SSD-11606719 – DADEC Throughput Increase – EPA Response to Addendum Amendment and Submissions Report

Thank you for the referral to the Environmental Protection Authority (EPA) requesting review and advice on the *Eastern Creek REP Throughput Increase Addendum Amendment and Submissions Report* for the Eastern Creek Recycling Ecology Park, operated by Dial-A-Dump (EC) (Proponent), and located at 1 Kangaroo Avenue, Eastern Creek (Premises).

ATTACHMENT A

PRELIMINARY

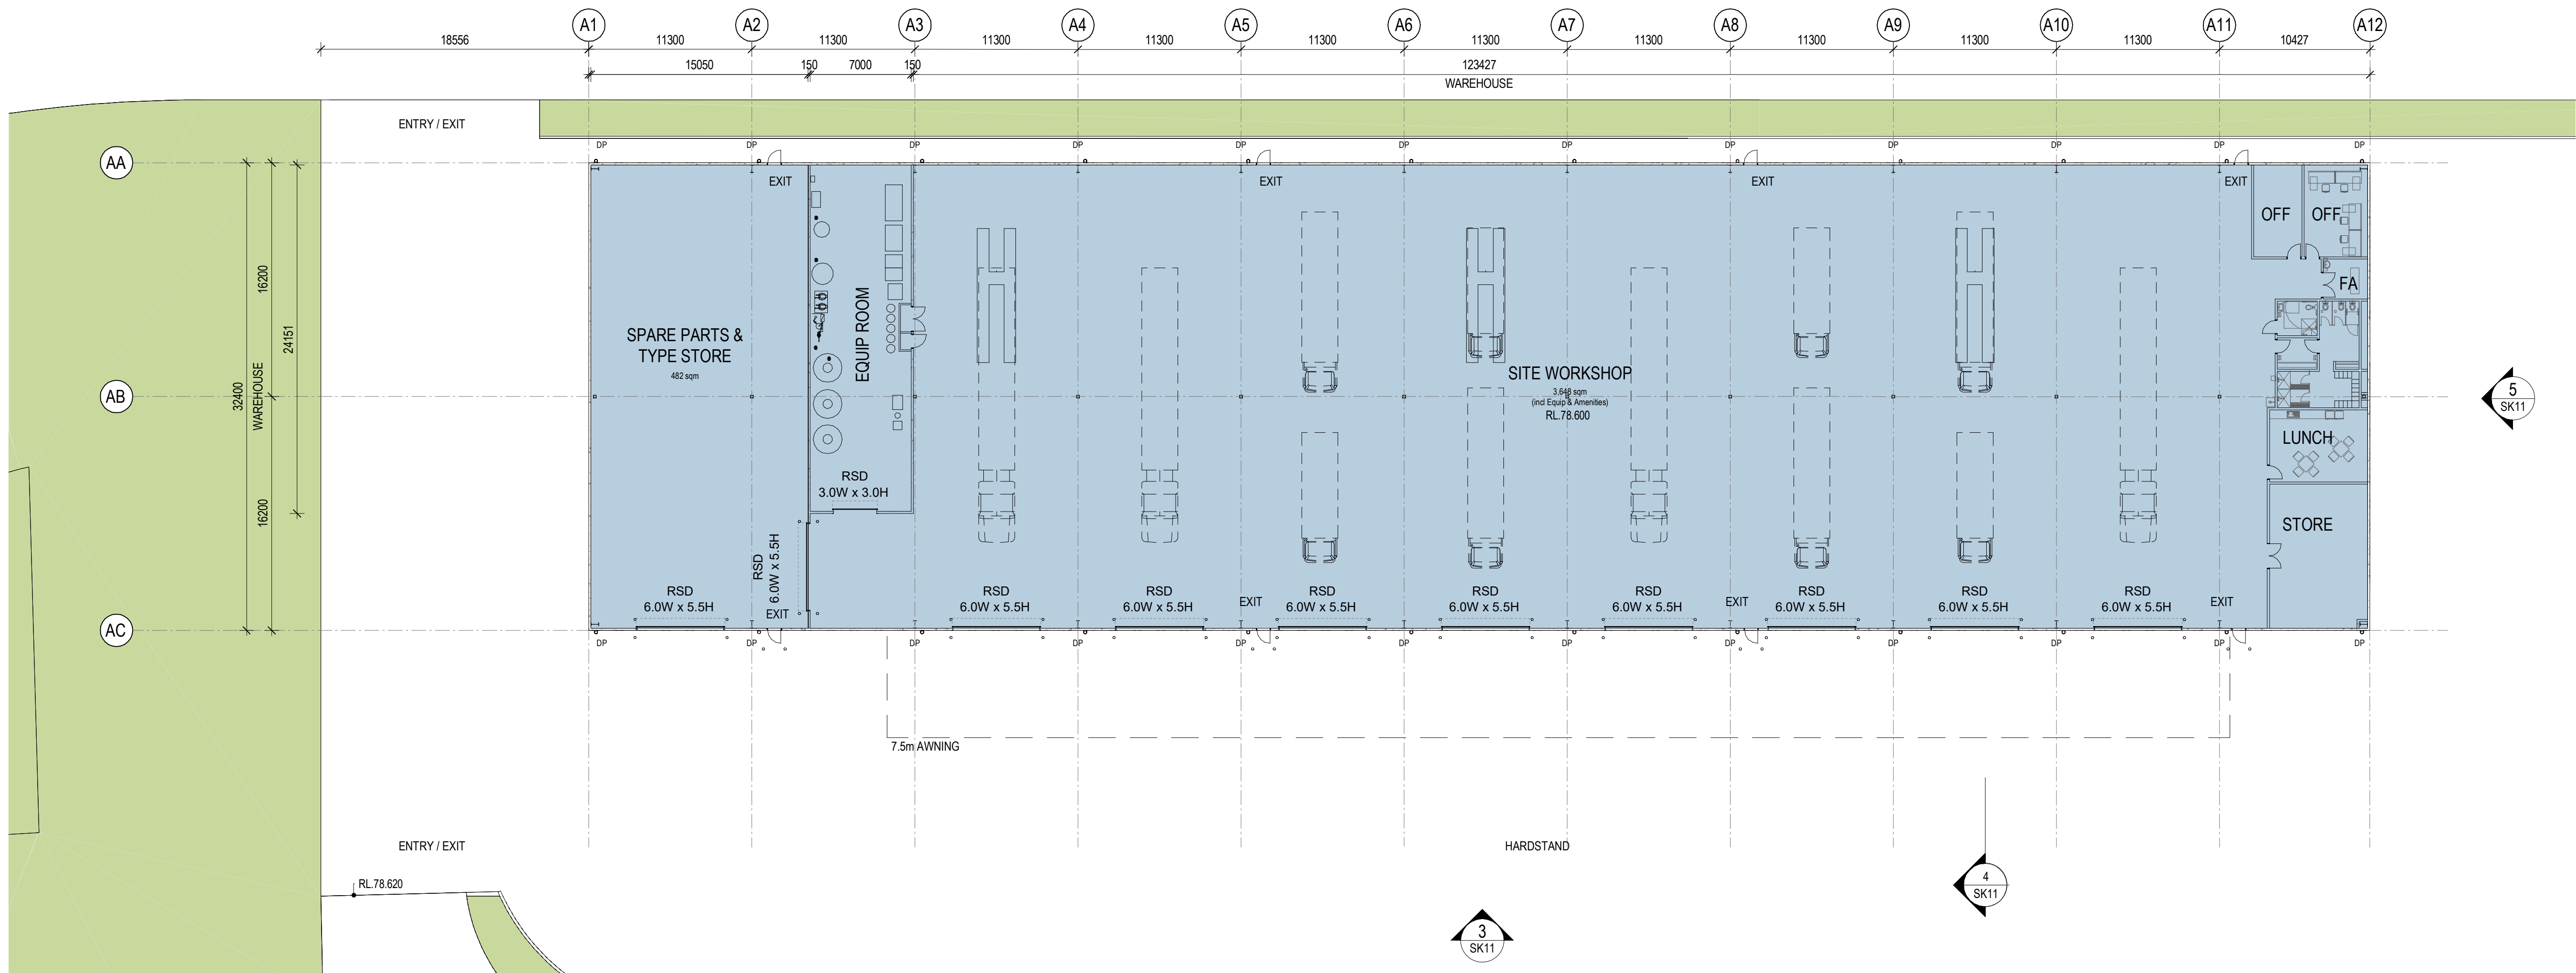
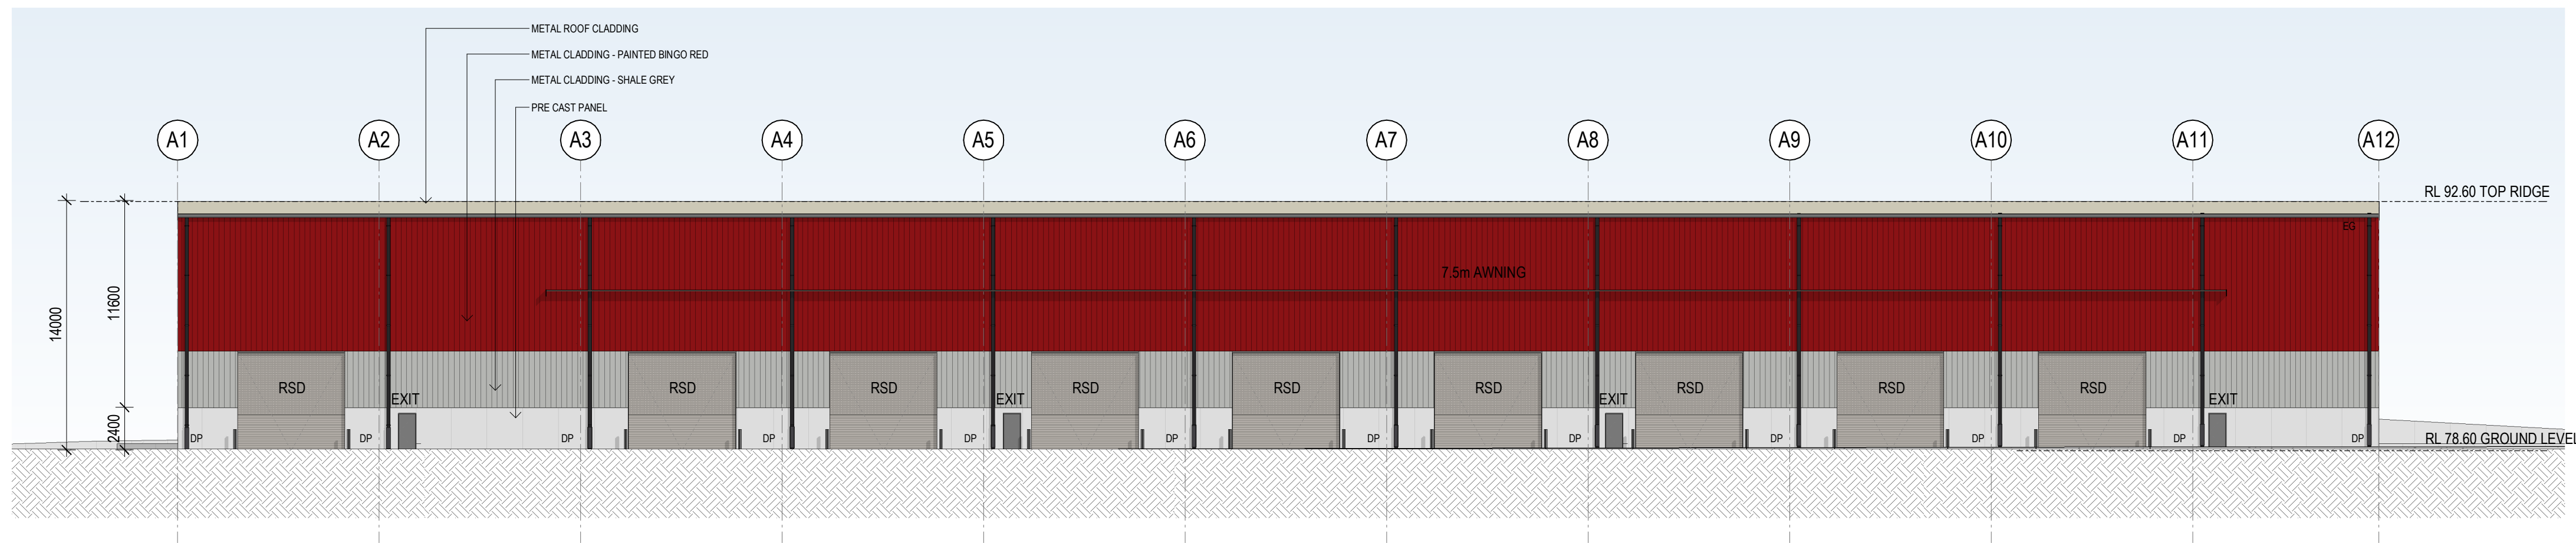
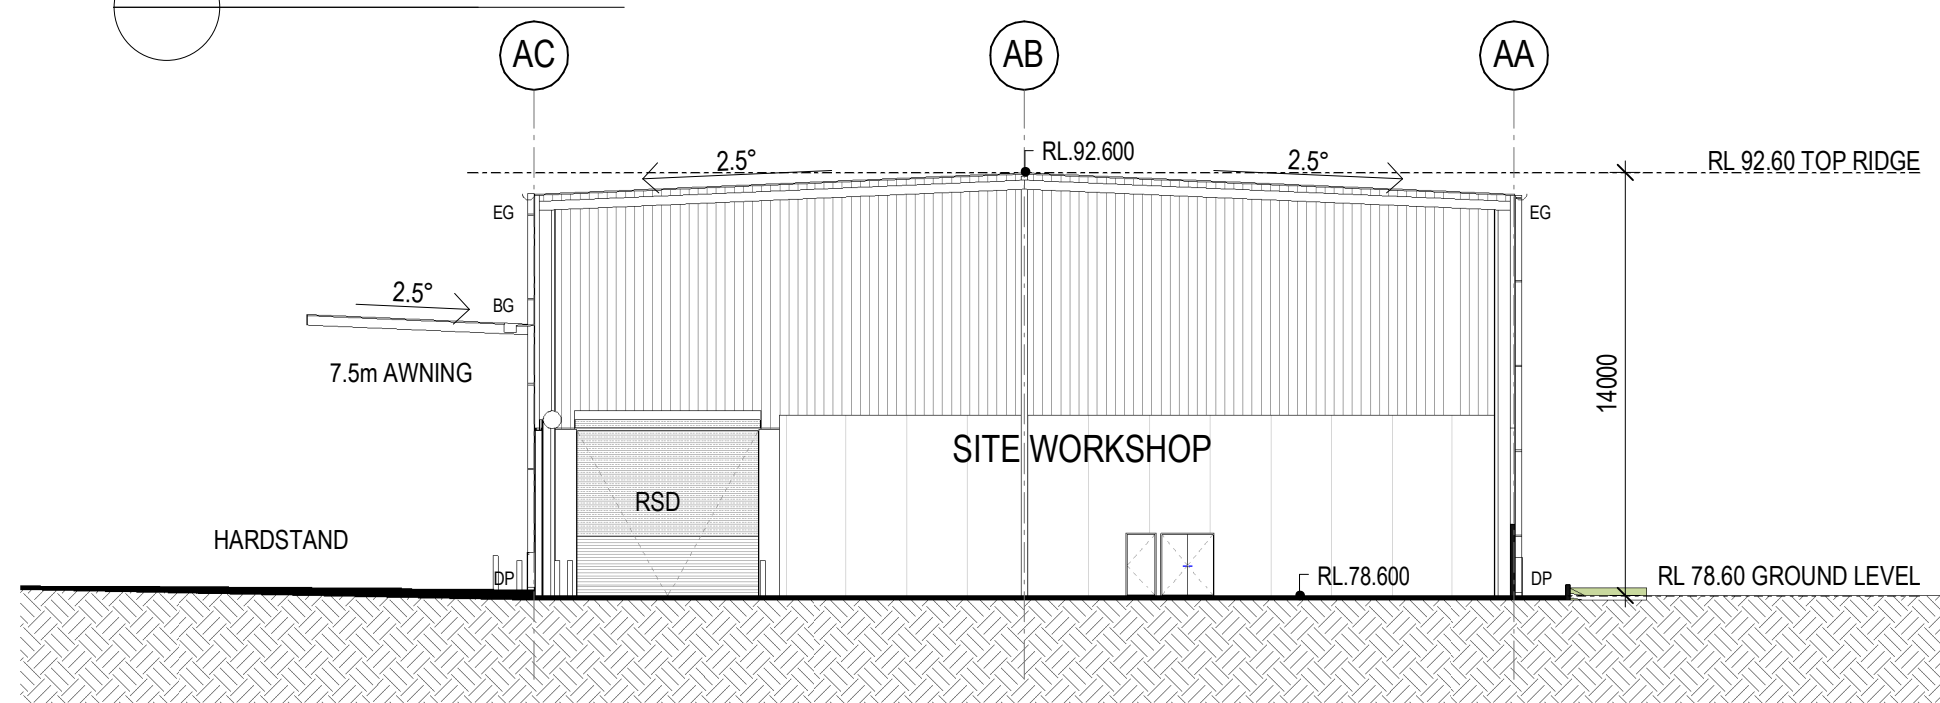
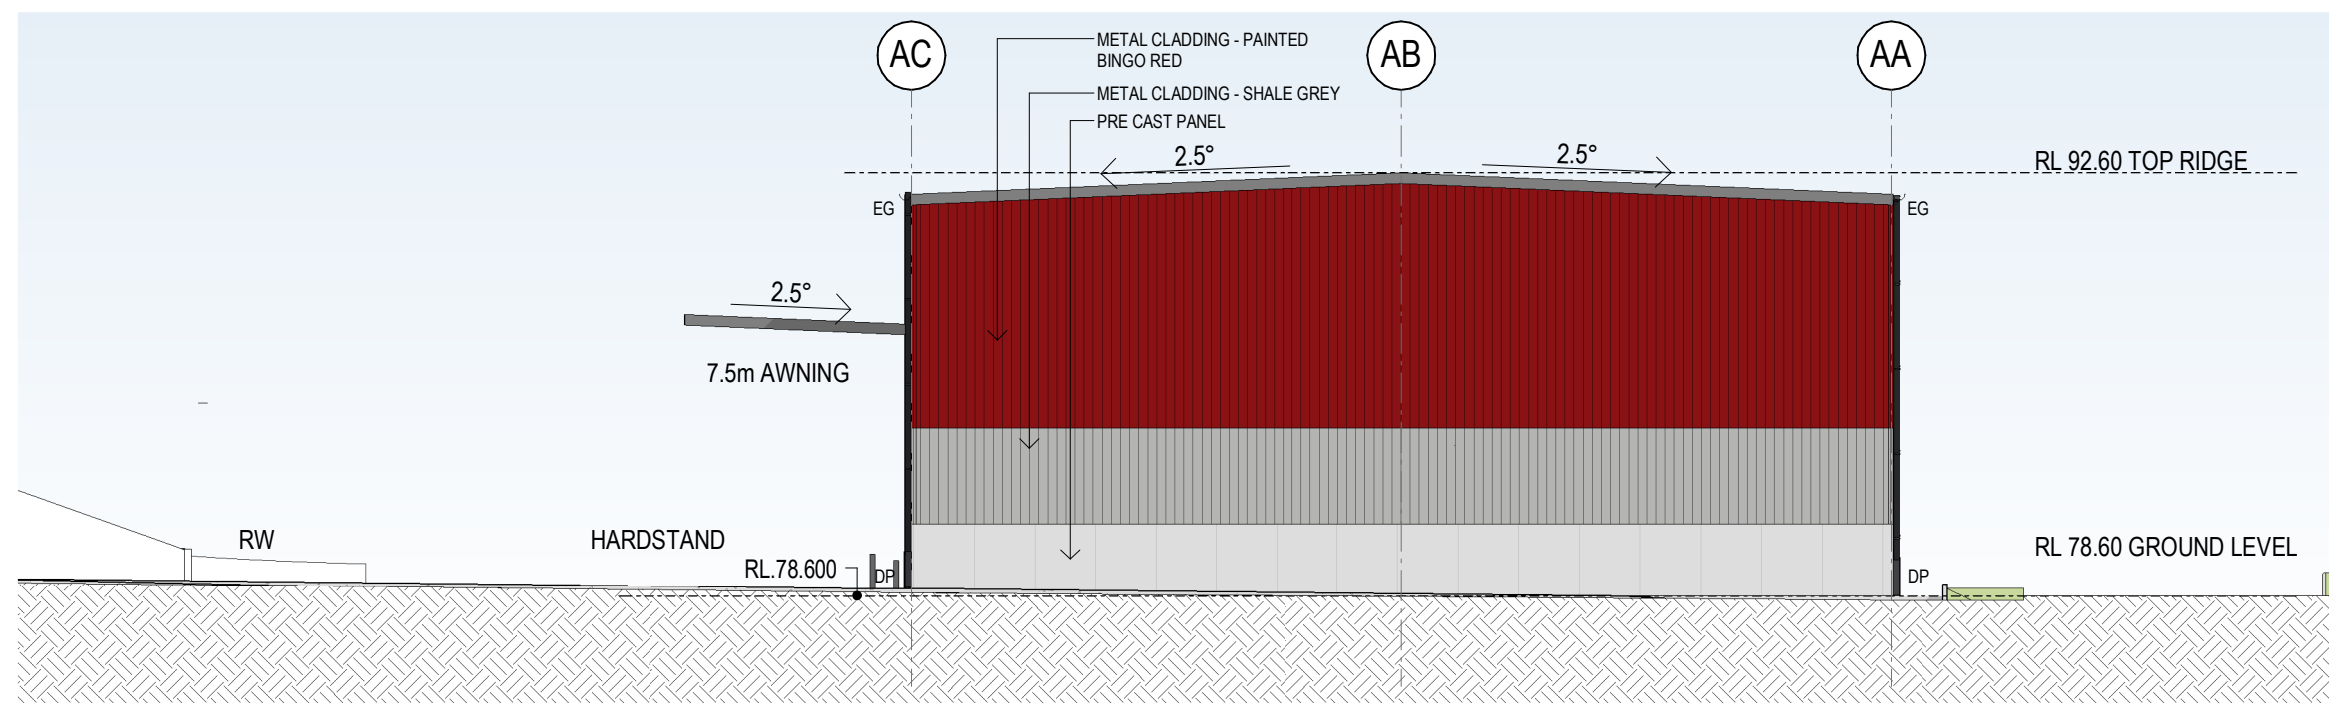
In Appendix A of the AASR, the Proponent provides inconsistent operating hours for the Site Workshop and Maintenance and Manufacturing Workshop. That is, the operating hours are proposed to be 12 hours per day between 6am and 6pm, consistent within existing approved hours of operation for the Eastern Creek REP. However, in Table 1-12 these hours are described as:

Monday – Friday 6:00am to 6:00pm
Saturday Sunday and Public Holidays - 5:00am to 9:00pm

The revised NVIA assumed the Site Workshop and the Maintenance and Manufacturing Workshop would be operational from 6am – 6pm, each day (including weekends and public holidays). The EPA recommend that should the proposal be approved, it be conditioned to include hours of operation for the Site Workshop and the Maintenance and Manufacturing Workshop accordingly.

The Site Workshop and the Maintenance and Manufacturing Workshop operating hours are 6am – 6pm, each day.
